## WelHatCycling response to Campus East Welwyn Garden City planning permission reference 6/2022/2801/MAJ

### **Campus East – objection**

FIG 53 - CYCLE PARKING STRATEGY

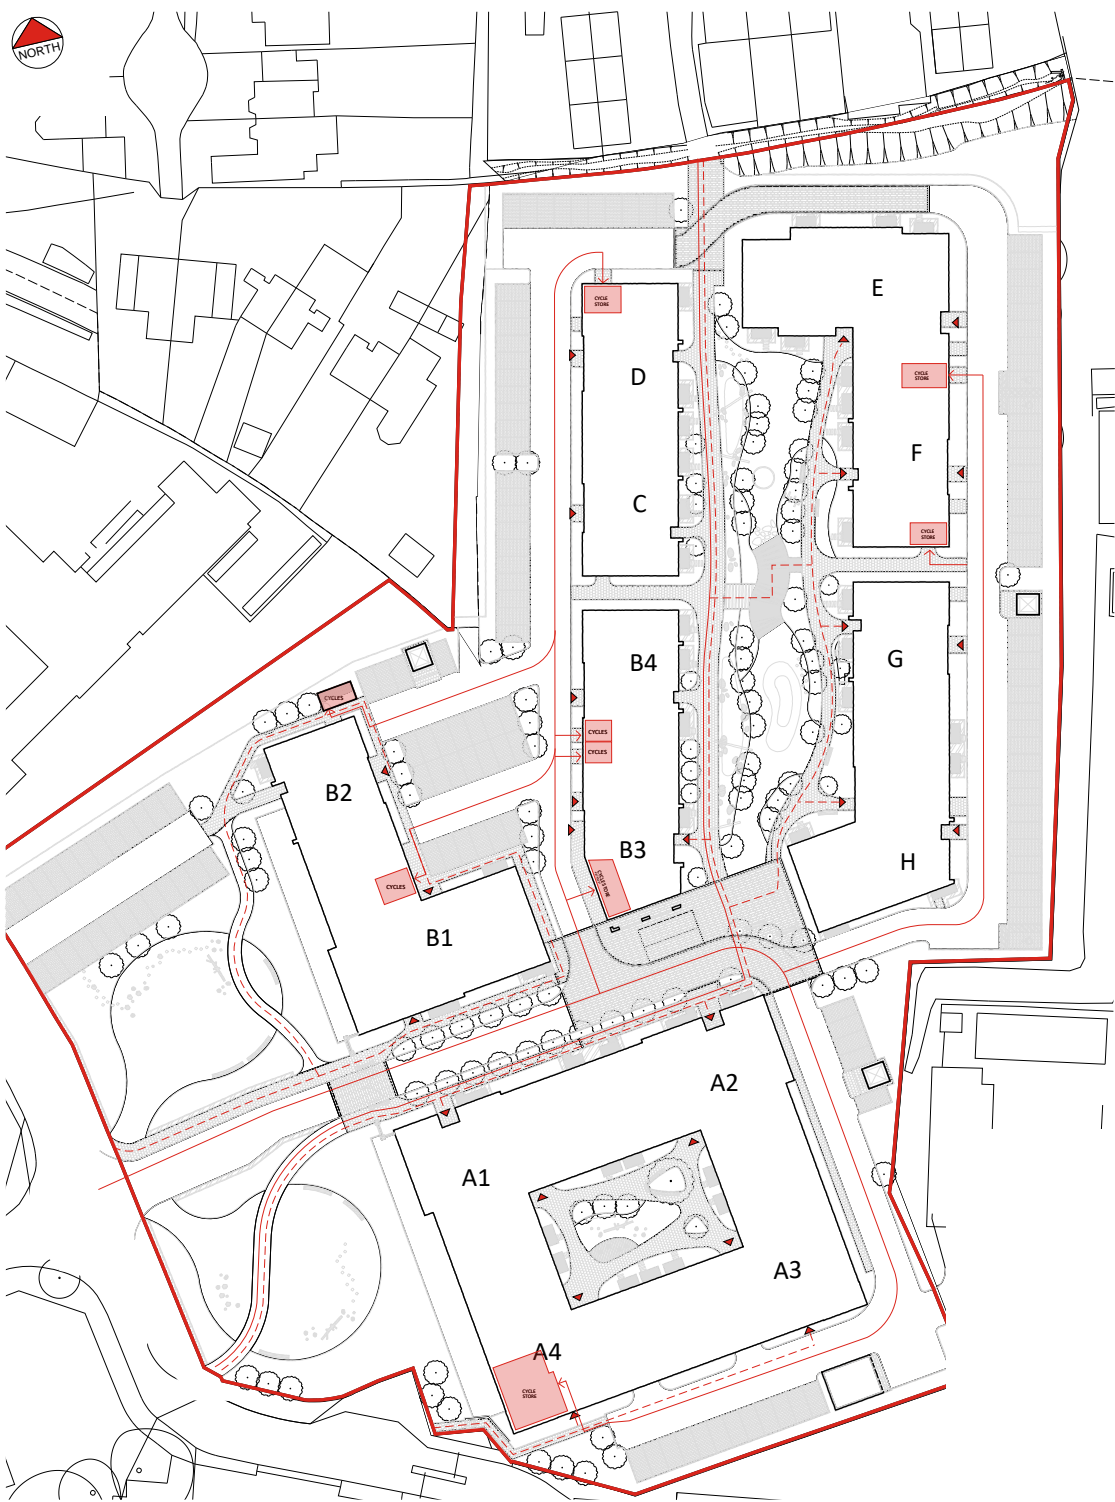
The Transport Assessment for the Campus East development of 313 flats makes no mention of LTN 1/20 which was published in June 2020. As a consequence, the plan for the cycle route across the development, shown in Cycle Strategy plan 8375/P121.2, fails to meet the requirements of LTN 1/20 section 14.3.7:

In the case of Campus East there are two obvious cycle routes which the plans fail to provide:

- A direct safe cycle route from the development to Bridge Road where there is a brand new cycle path due to open in January 2023 and via that route to the town centre shops, rail and bus stations. This is a distance of just 0.1 mile. Instead, the developers propose people on cycles should head north out of the site via Gresley Close, Mundells and Bessemer Road to WGC, a distance of 2.1 miles.
- An of-road cycle route via Oaklands College to Campus West (library, cinema, roller skating) and then the Ayot Greenway, part of National Cycle Route 12. This is a distance of 0.3 miles. Instead the Transport Assessment simply assumes local roads are safe. The Campus is an

unsafe road for a child to cycle and is an extremely challenging road to cycle for an adult, due to high speeds and the need to cross merging and diverging traffic lanes.

WelHatCycling will withdraw its objection if the following two routes are agreed to be provided and will be open to residents before the first flat is occupied:

- 1) **A 0.1 mile off road cycle path from the south-west corner of the site on College Way to the new cycle path on Bridge Road.**
  - A footpath exists to the west side of Waitrose or use the wide footway to the west of Welwyn Hatfield Borough Council’s offices.
  - The existing traffic light controlled crossing of Bridge Road could be upgraded to a Toucan (pedestrian and cycle crossing) to enable a safe crossing to the new cycle path.
- 2) **A 0.3 mile off road cycle path from the south-west corner of the site on College Way via Oaklands College to Campus West and the Ayot Greenway.**
  - There is ample space along the footway around the edge of The Campus for this.
  - A safe signalised crossing of Digswell Road or a route under the White Bridge will be needed given the high traffic flows at this crossing.
